CITY OF ALBUQUERQUE

Re: Ibarra Garage Work Order Sheet 6, 90th St and existing alley
Engineer's Stamp -no stamp- (K9/D034)

Re: Ibarra Garage Grading and Drainage Plan
Engineer's Stamp dated 3-24-09 (K9/D034)

Re: Ibarra Garage Grading and Drainage Plan
Engineer's Stamp dated 2-4-08 (K9/D034)

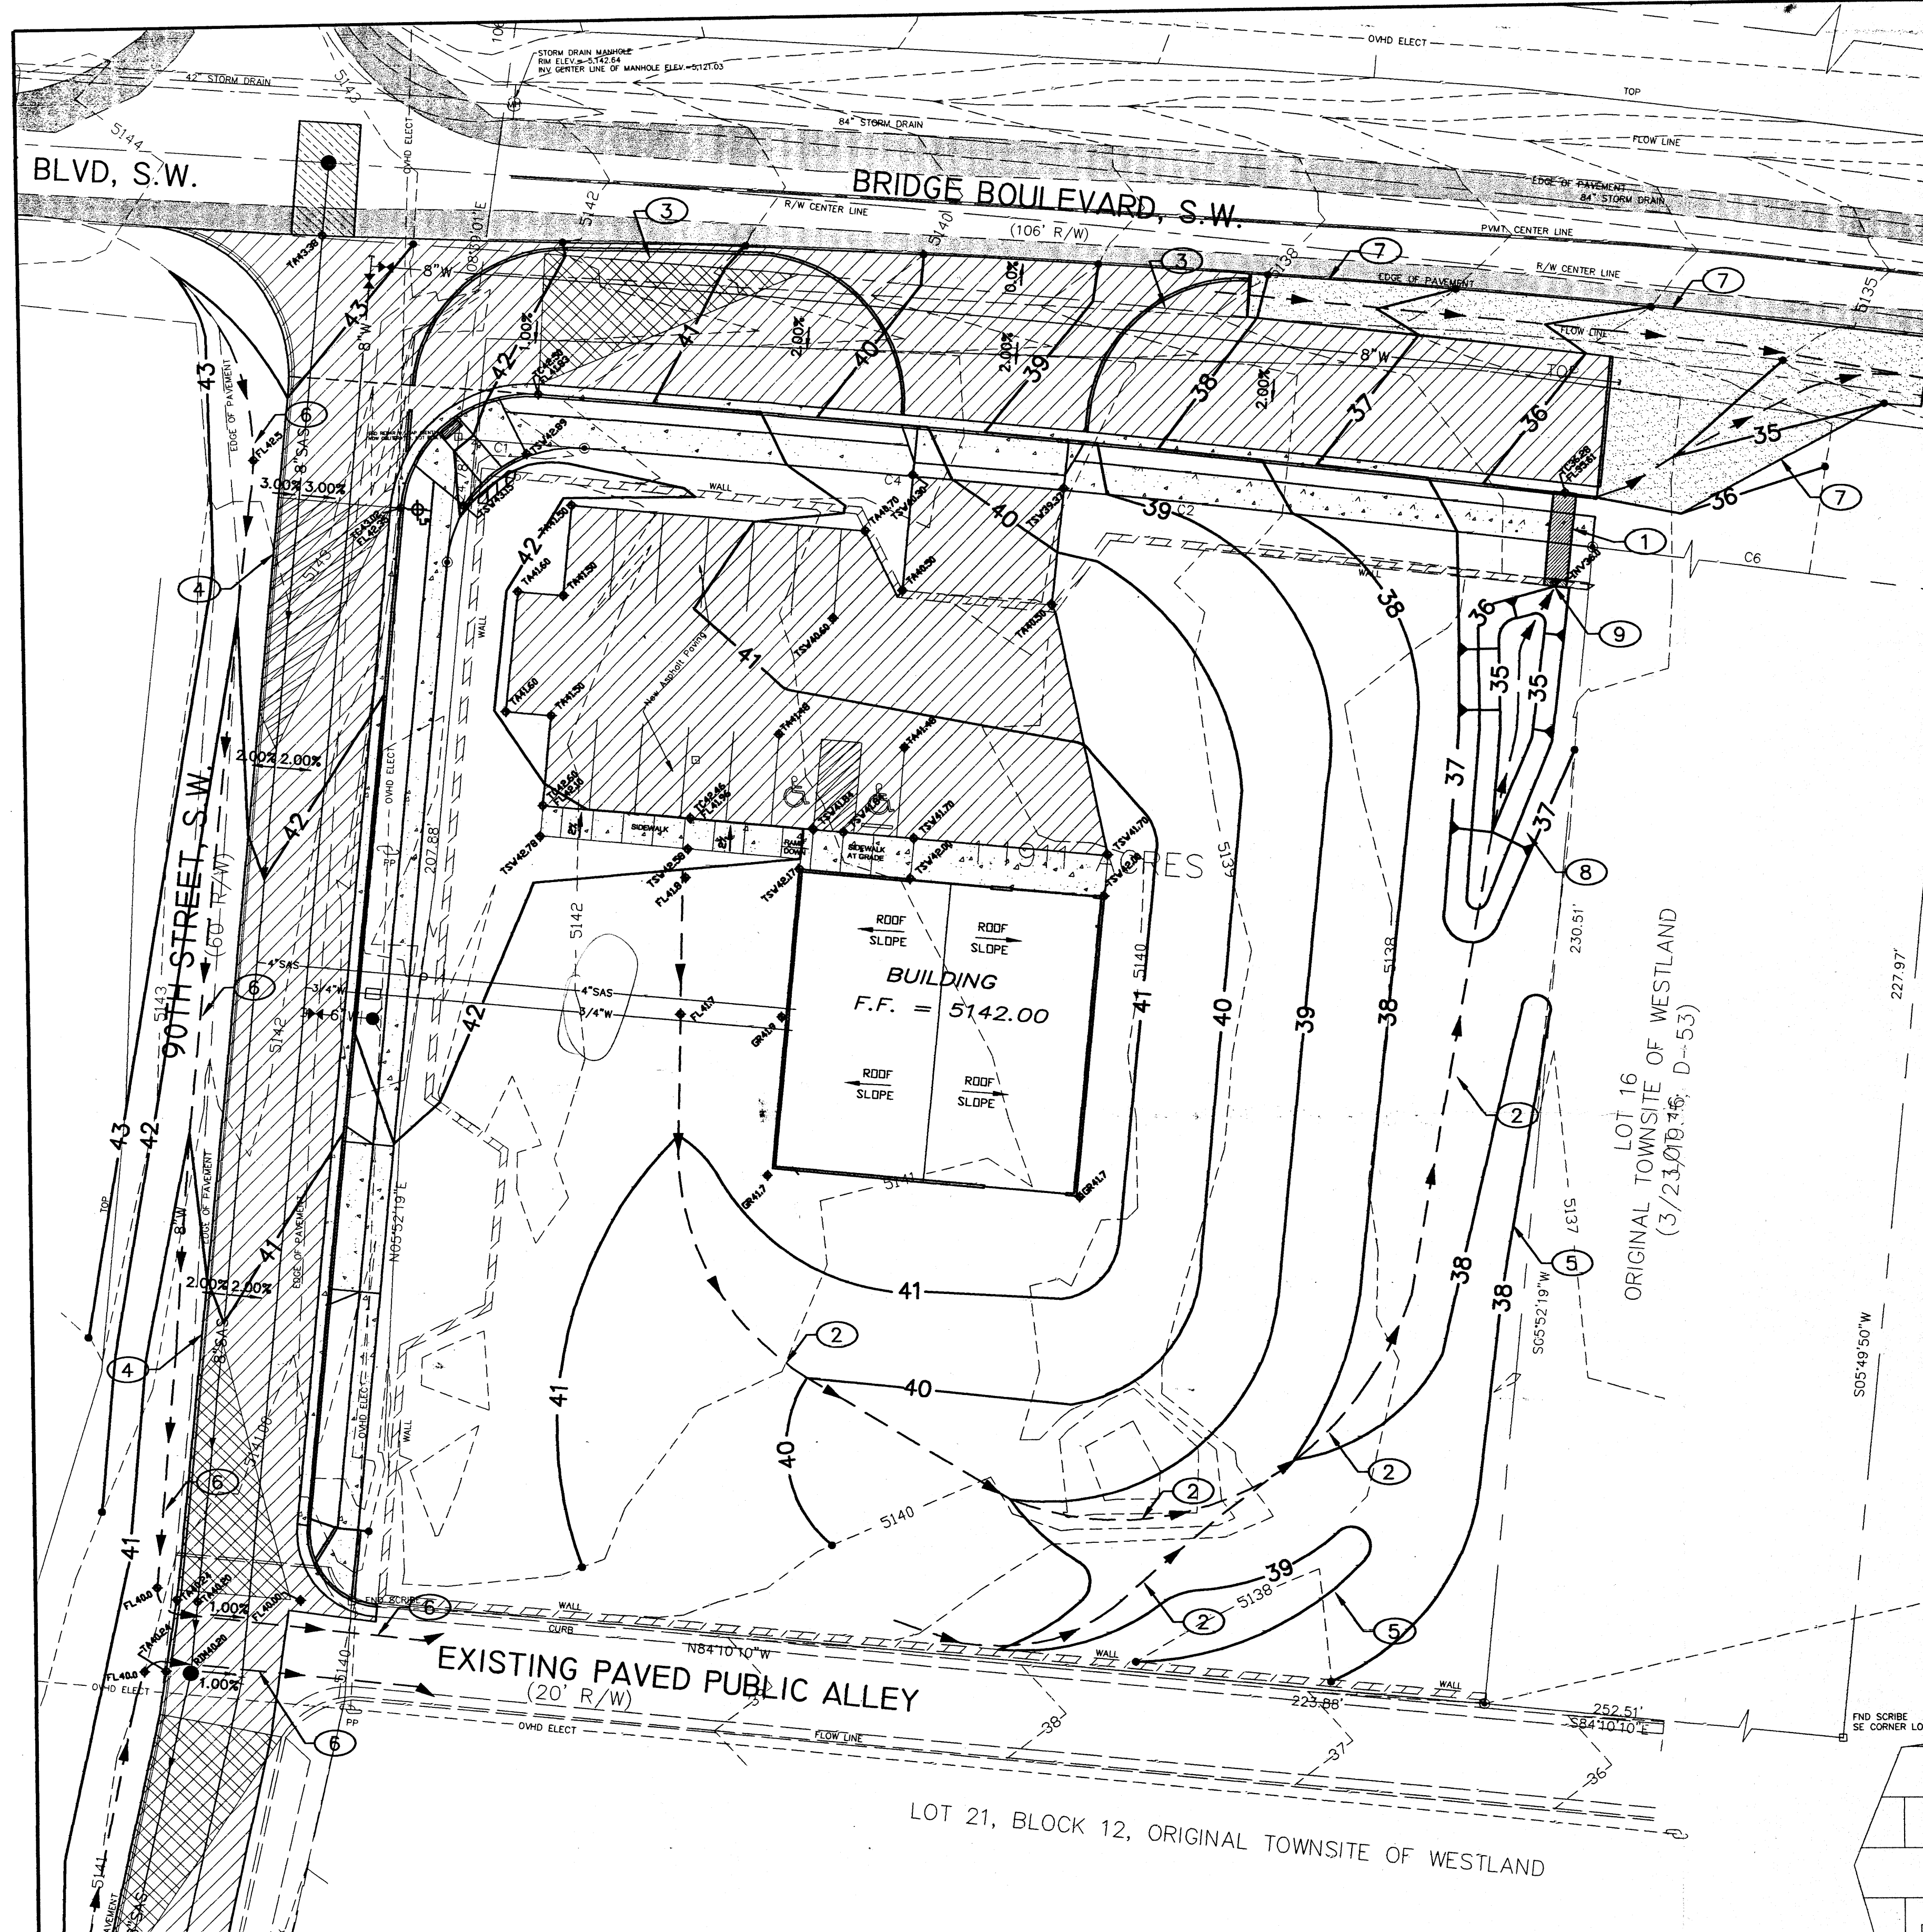
- Sidewalk culverts per COA STD DWG 2236 are a maximum of 2' wide. Widths greater than this require a detail. Also, sidewalk culverts extend to the face of curb.
- Provide a detail for the 3' rundown upstream of the sidewalk culvert with an invert.
- It is foreseeable that the dirt portion of this site will be paved. Therefore, size the sidewalk culvert for land treatments 90%D 10% C (~5.4 cfs).
- In addition, provide a desilting pond upstream of the sidewalk culvert to prevent sediment from entering the ROW.

1. The sidewalk culverts now shown are 2 culverts at 18" width per COA STD DWG 2236 and extend to the face of curb.
2. We are extending the same sidewalk culvert section to the wall, a detail has been added for the penetration through the wall along with an invert.
3. I have increased the flows based on 90%D and 10%C, I believe this is excessive but looks like the proposed 2-18" wide culverts can handle this flow since it was designed as a weir and in reality would act more like a channel entry.
4. A desilting pond upstream of the sidewalk culvert as been added.

Also attached is a corrected detail sketch for the valley gutter (per STND DWG. 2422) and a detail to be added for thickening the west end of the VG to act as a shallow cut-off wall and provide a keyway for future tie-in and extension of the VG to the west (future) curb & gutter.

Another concern noted on your plan was the $\pm 6"$ "pond" in the swale just west of the new VG. Please fill it in to avoid a "puddle" adjacent to the pavement edge.
